12 February 2026

Jack Turner
Team Leader
Department of Planning, Housing and Infrastructure

Bengalla Open Cut Coal Mine (SSD-5170) Modification 8 – Muswellbrook Shire Council comments on Modification Report

APPENDIX 4 LAND OWNERSHIP

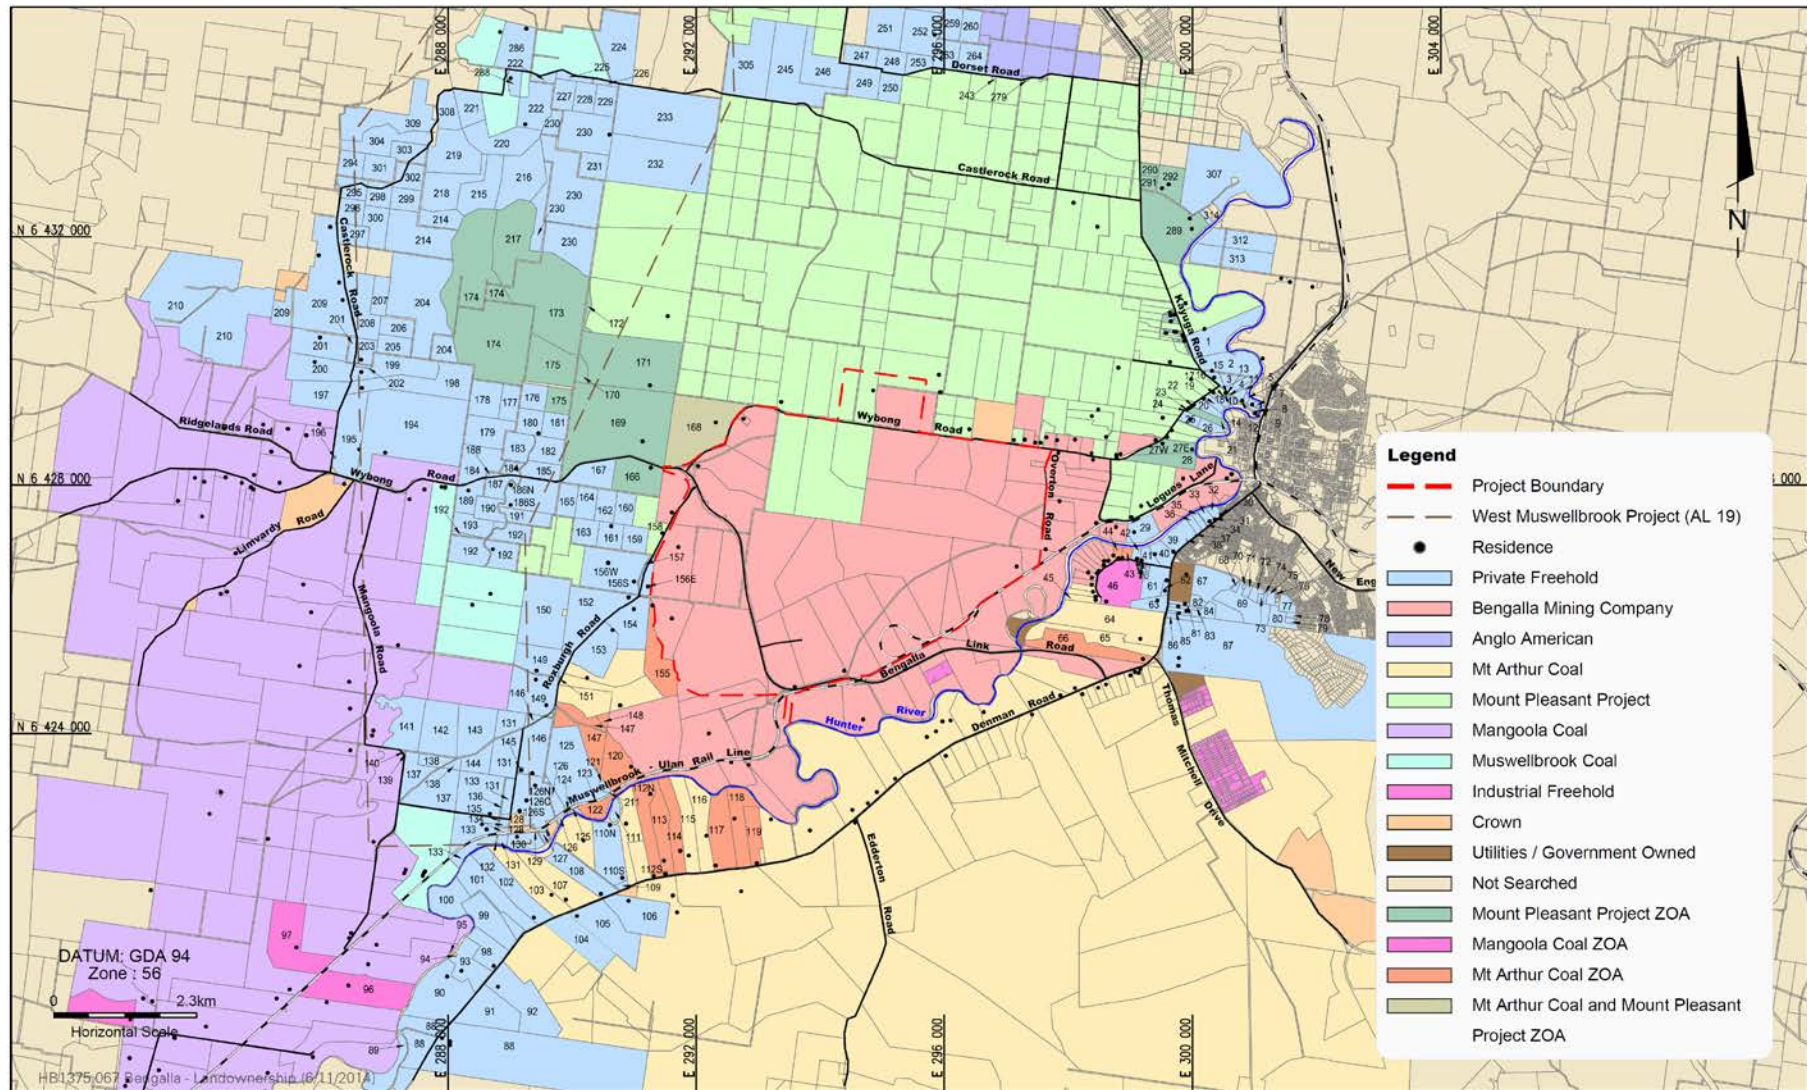
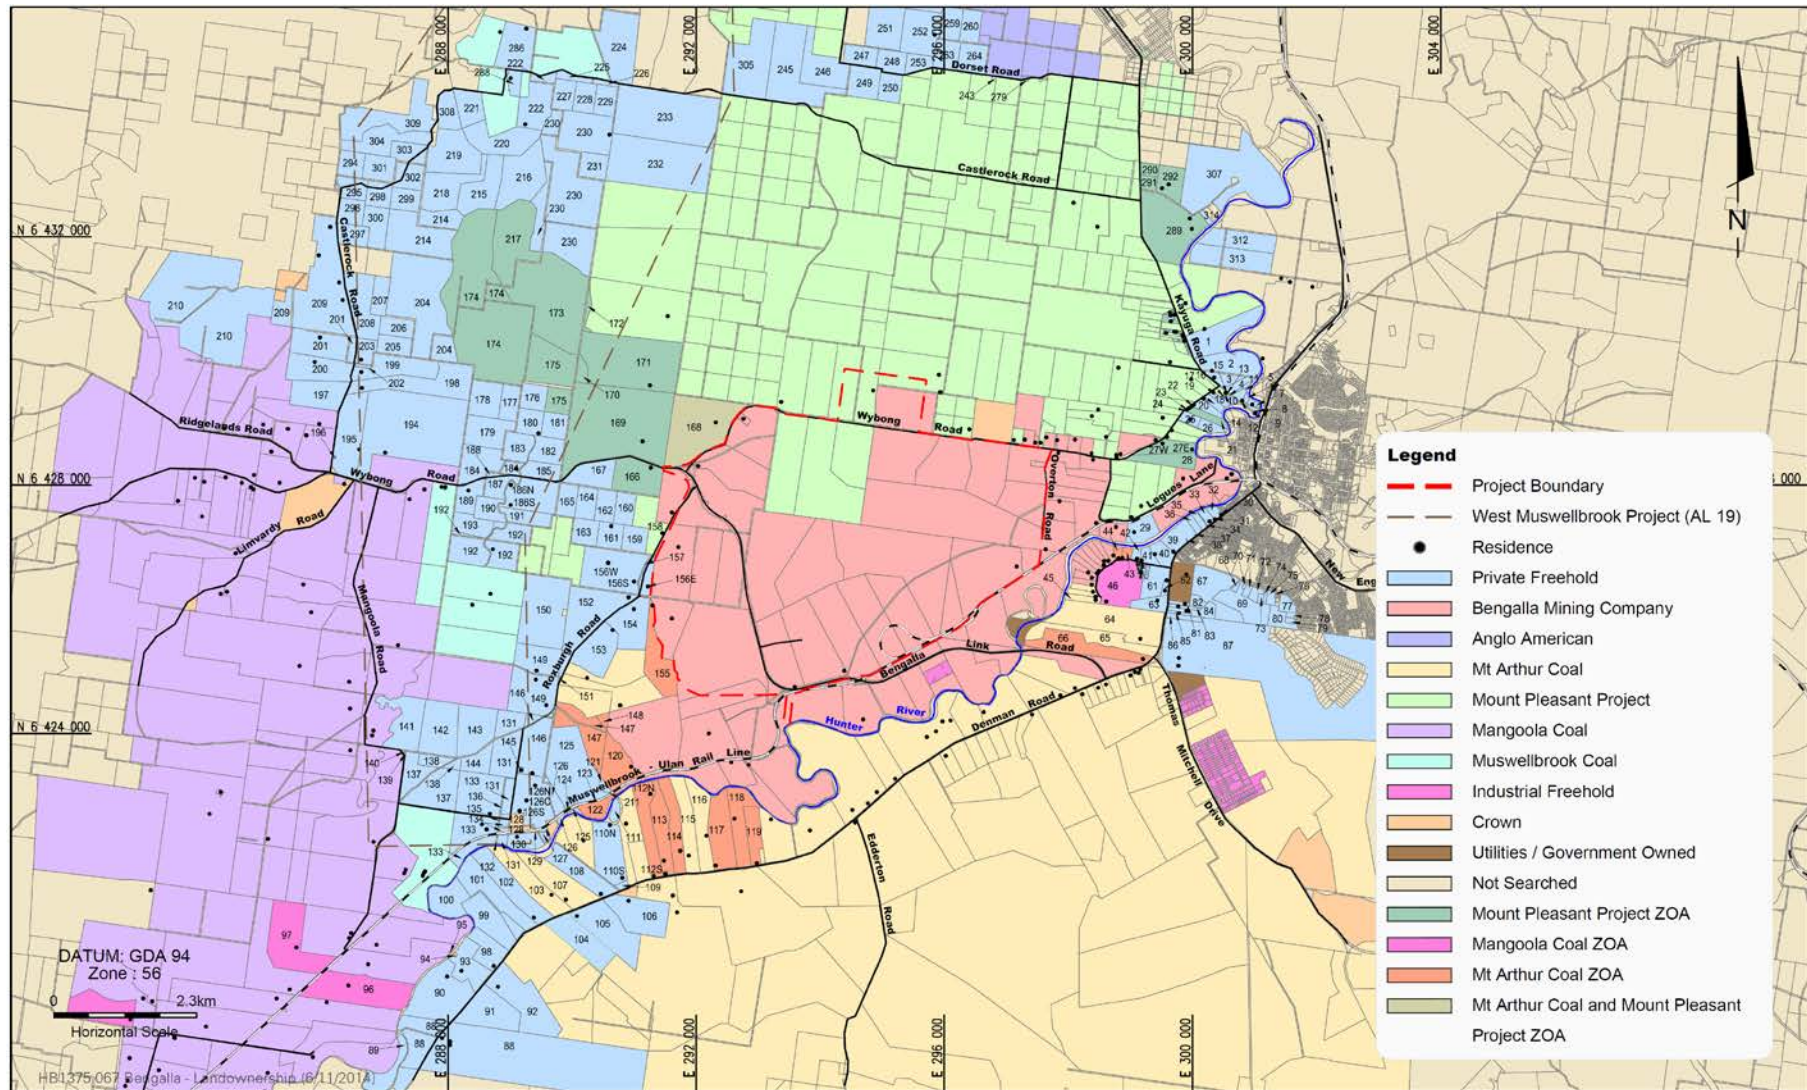
11. It is assumed that the noise acquisition rights applicable to Receiver 156 (identified as Receiver 156S in Appendix 4 of SSD-5170) would apply to operational noise associated with the Modification.

12. For completeness, Council requests confirmation as to whether Receiver 156E, shown in Appendix 4 of SSD-5170, is no longer a dwelling. If confirmed, Council recommends that this receiver be removed from the development consent to ensure the approved documentation remains accurate.

APPENDIX 8 CONCEPTUAL REALIGNMENT OF BENGALLA LINK ROAD

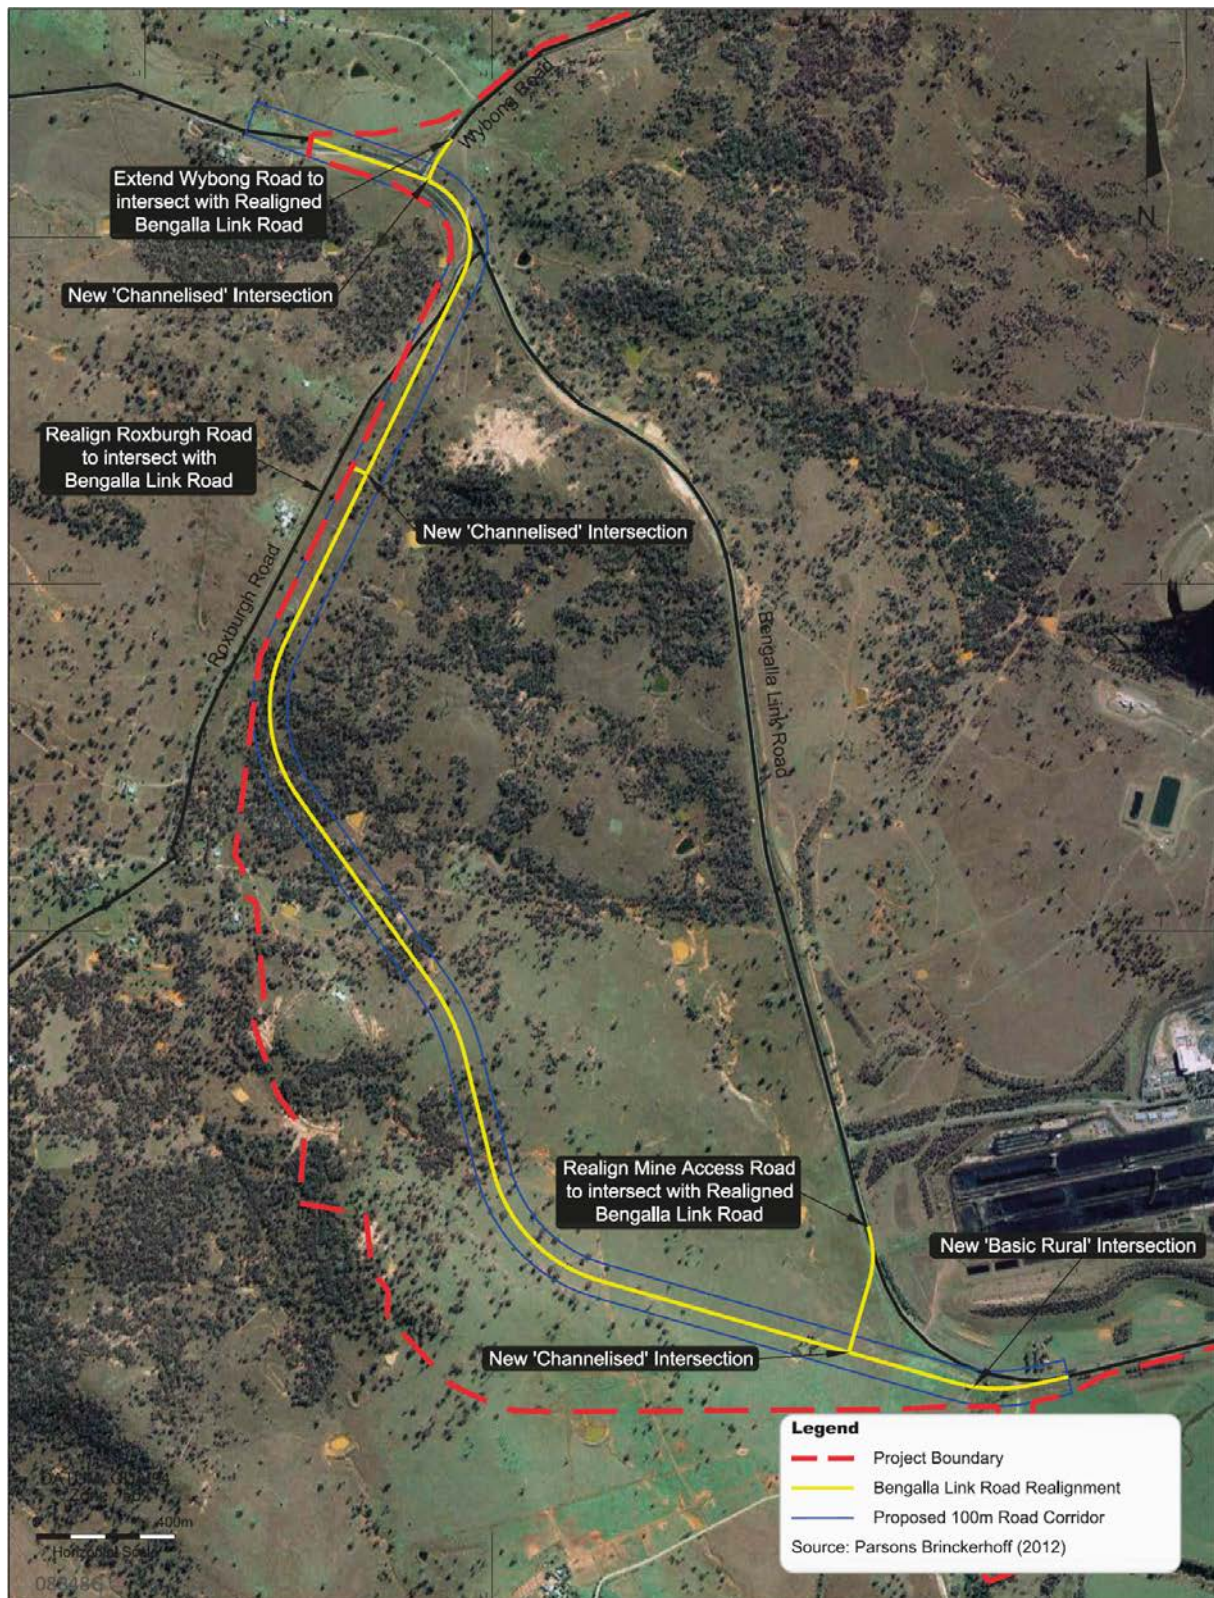
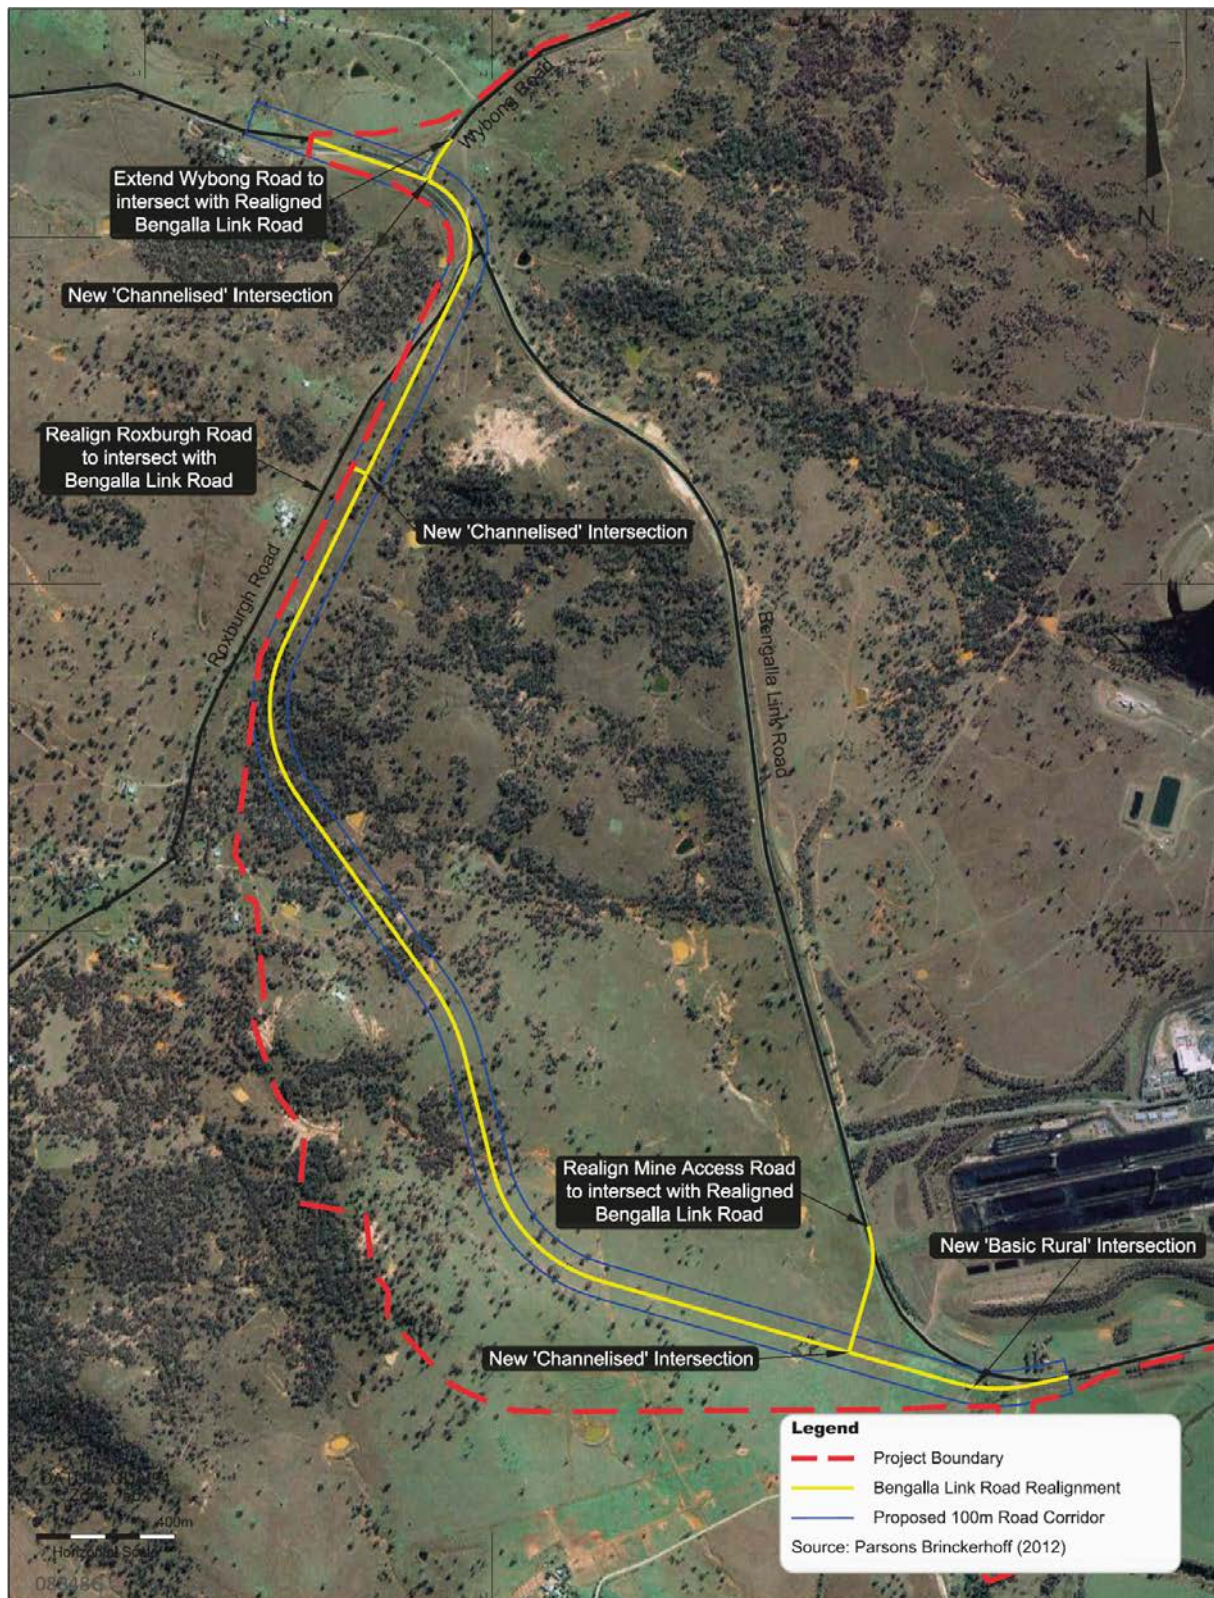
1. Notwithstanding the preparation of the Deed, it is the preference of Council that the Modification supports and aligns with the Deed by describing, and where relevant illustrating (including figures suitable for incorporation into the development consent), the following key aspects of the proposed Modification. This will ensure transparency, regulatory clarity and avoid ambiguity between the approved development and the contractual arrangements that it will give effect to. While some of this information is referenced in Appendix H of the Modification Report, the level of detail provided is insufficient to clearly identify the scope of works and associated obligations.

- Road realignment/s.
- Road decommissioning.
- Road closures (including the unnamed roads shown in Figure 1).
- Roads identified for purchase and transfer.
- Changes to rights of way and rights of carriageway.
- Construction access points, construction affected public roads and prohibited roads.
- Roads to be maintained by BMC, including those currently maintained under existing arrangements, any new roads proposed to be maintained as part of the Modification, and the portion of the realigned BLR to be maintained by MACH Energy in accordance with Condition B103 of SSD-10418; and
- The location of third-party infrastructure, as described in Section 3 of the Modification Report.

5. Council does not support mining through the existing BLR or the unnamed roads (see Figure 1) prior to formal closure, as the road/s remain a public asset for which Council retains statutory responsibilities. Allowing mining to occur before closure would create legal and safety risks and undermine Council's ability to enforce closure. Formal road closure is therefore required to occur prior to any mining activities affecting the existing BLR or unnamed roads.
